Church Farm Accommodation
Church Lane
Bickenhill
Solihull
B92 0DN

The Inspector
M42 Junction 6 DCO Hearing
The Planning Inspectorate
Temple Quay House
2 The Square
Bristol
BS1 6PN

**Re. Representation of David and Camilla Burton of Church Farm Accommodation,
Church Lane, Bickenhill B92 0DN**

Deadline 6 Submission

**OPTION 1: INDICATIVE ALT. ARRANGEMENT TO REDUCE IMPACT ON CHURCH FARM LAND**

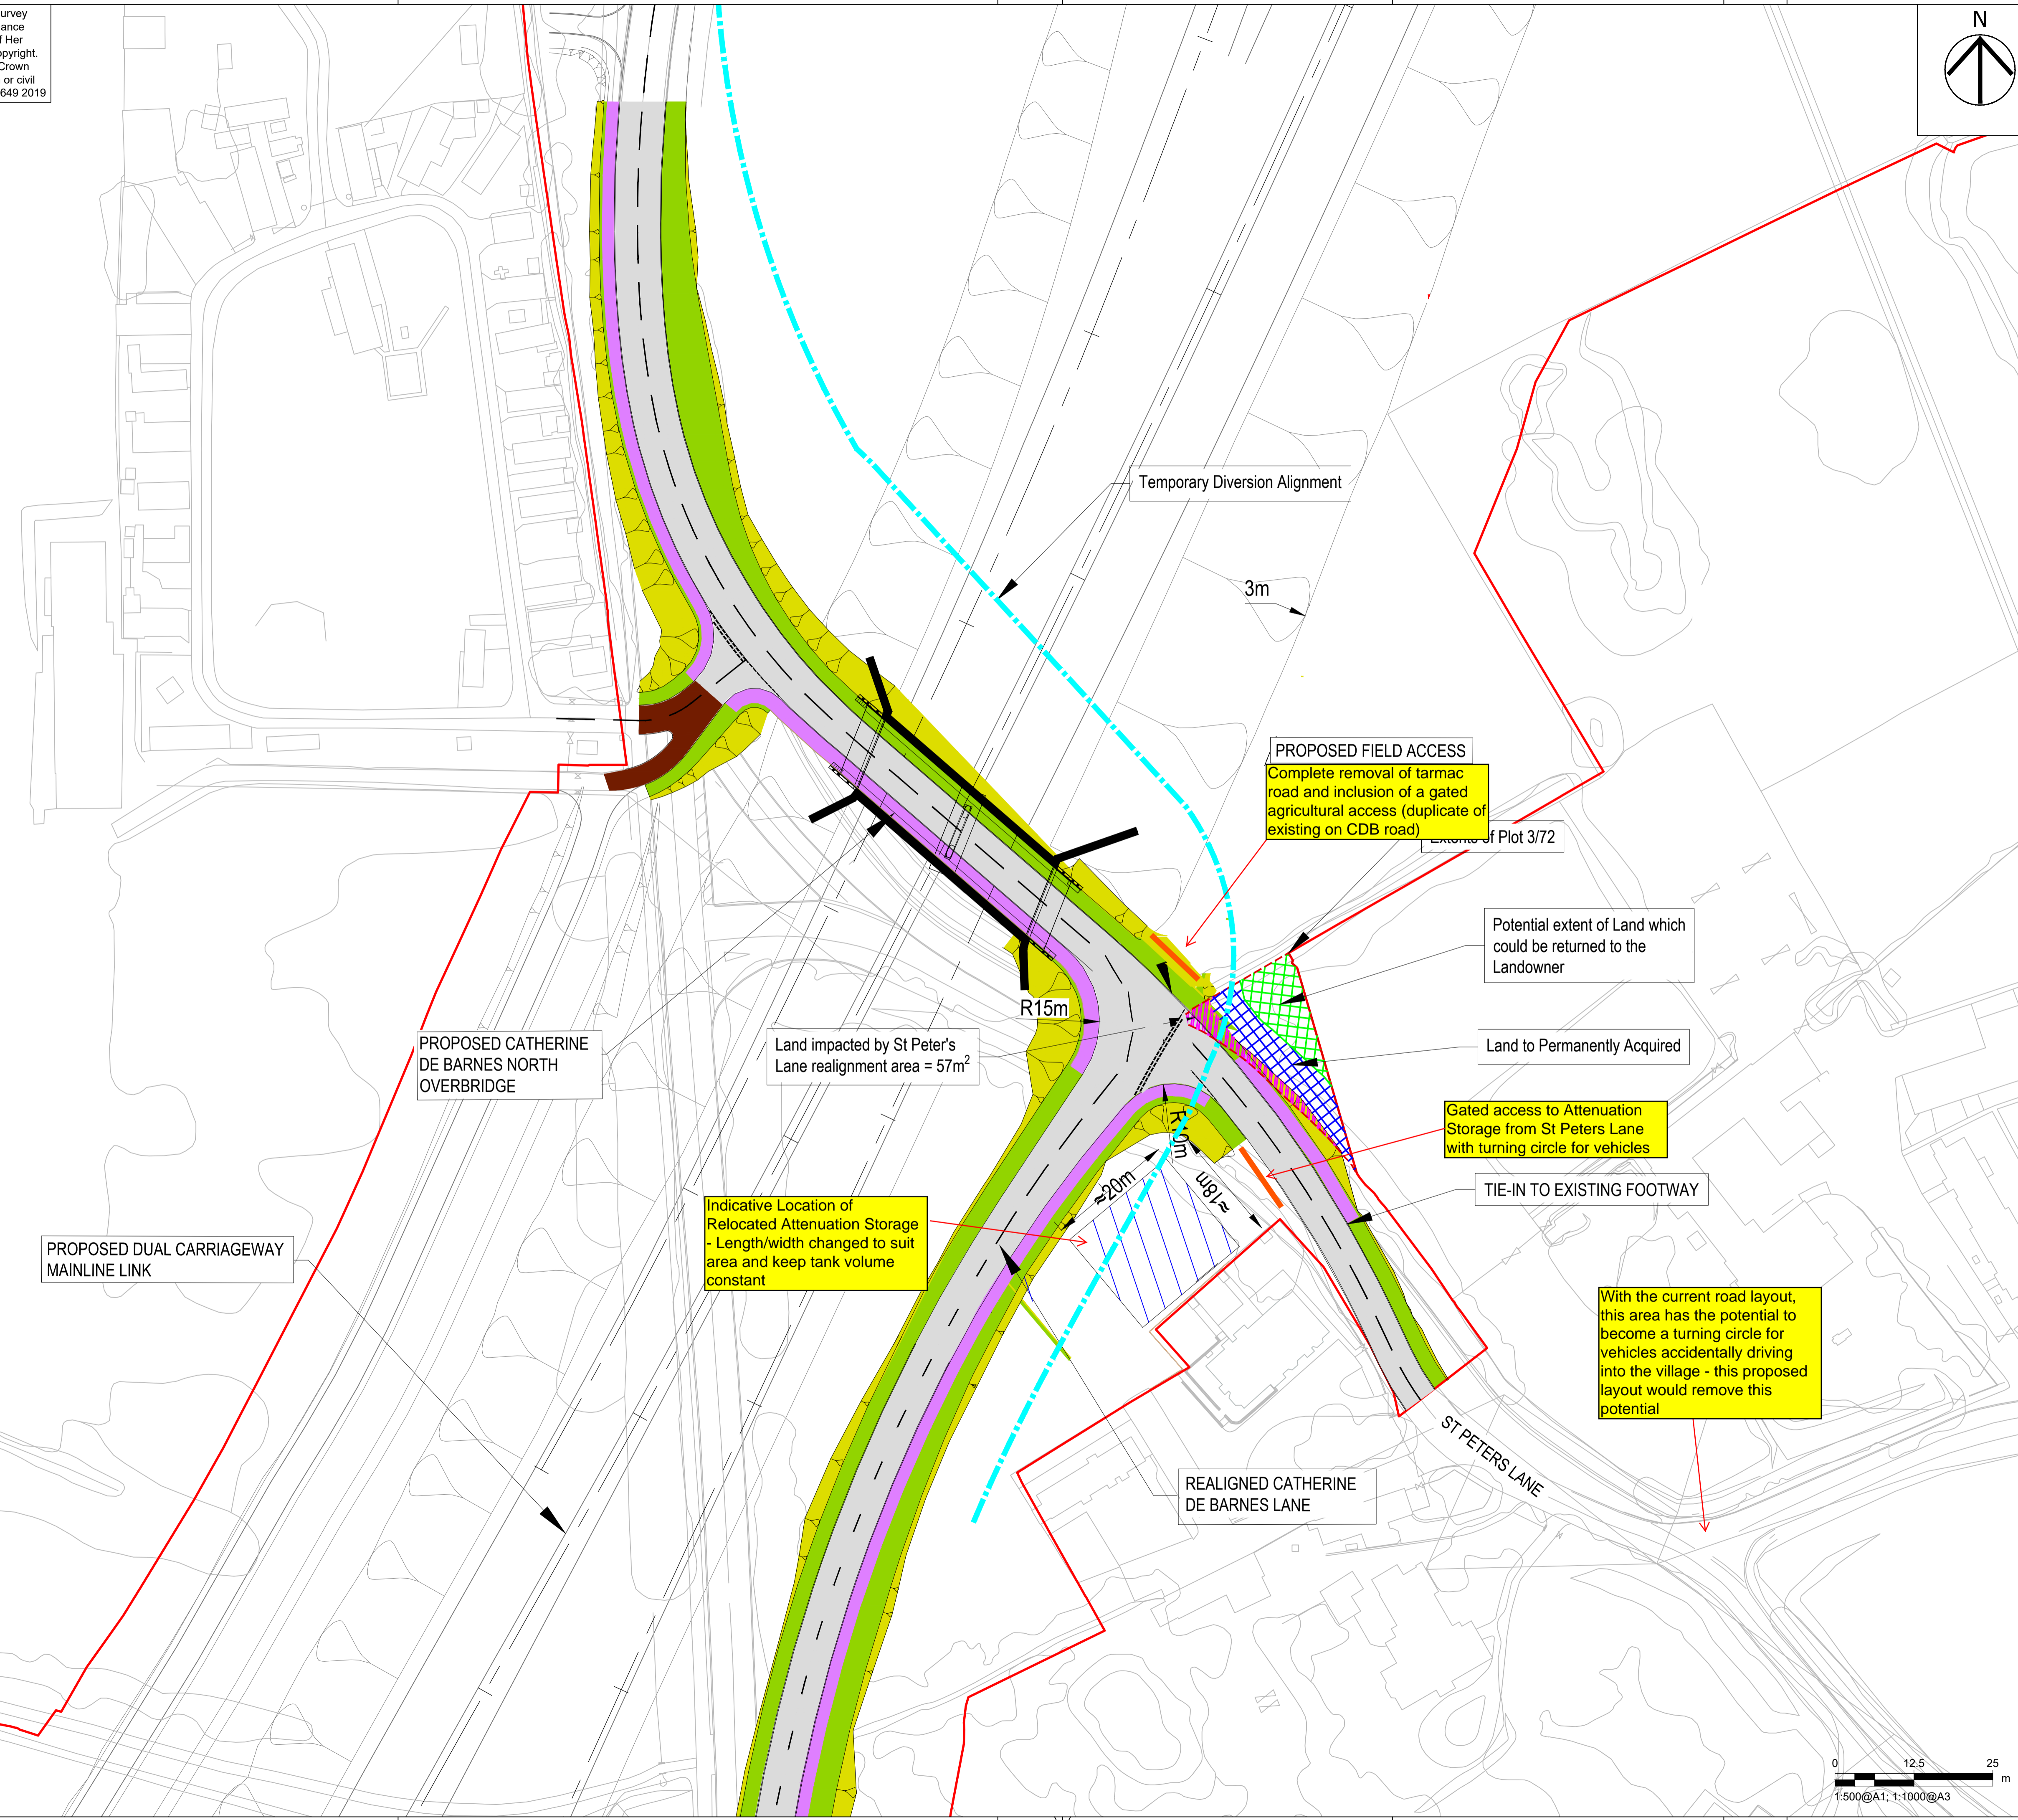
5. The current proposed route for the temporary realigned Catherine-de-Barnes Road will mean that the road will be located directly behind our property. We were told at the meeting on the 1st October that the road will take 2-3 months to construct which means we will have to endure the building of this road before the new road starts construction. The plan submitted from Highways shows that this re-routed road will come further into the village, immediately behind our property and this gives no space for any mitigation due to it's proximity to our boundary. Once the road is built there will be two lanes of traffic running 24/7 approximately 60m away from my guest rooms. This will be in use whilst the bridge is being constructed which I have been told by highways will take 9months-1 year! We are struggling to see how our guests will have a good experience staying whilst there is this level of disruption with no bunding other than an acoustic fence which will not be sufficient or very effective for noise of this level. For this reason we need Highways to move this temporary road further away or find an alternative route that does not further disrupt our home and business.

6. The removal of the Attenuation tank located behind my property as this means putting in an access road in an area that is currently does not have one. This has the potential of opening up this area at the back of my property, giving rise to unwanted parking, fly tipping, taxi parking and giving ease of access to our property, increasing the risk of crime and other undesirable activities as previously stated on my representations at deadline 4 and 5. This also adds to the lack of space for mitigating the noise created by construction of the bridge and road.
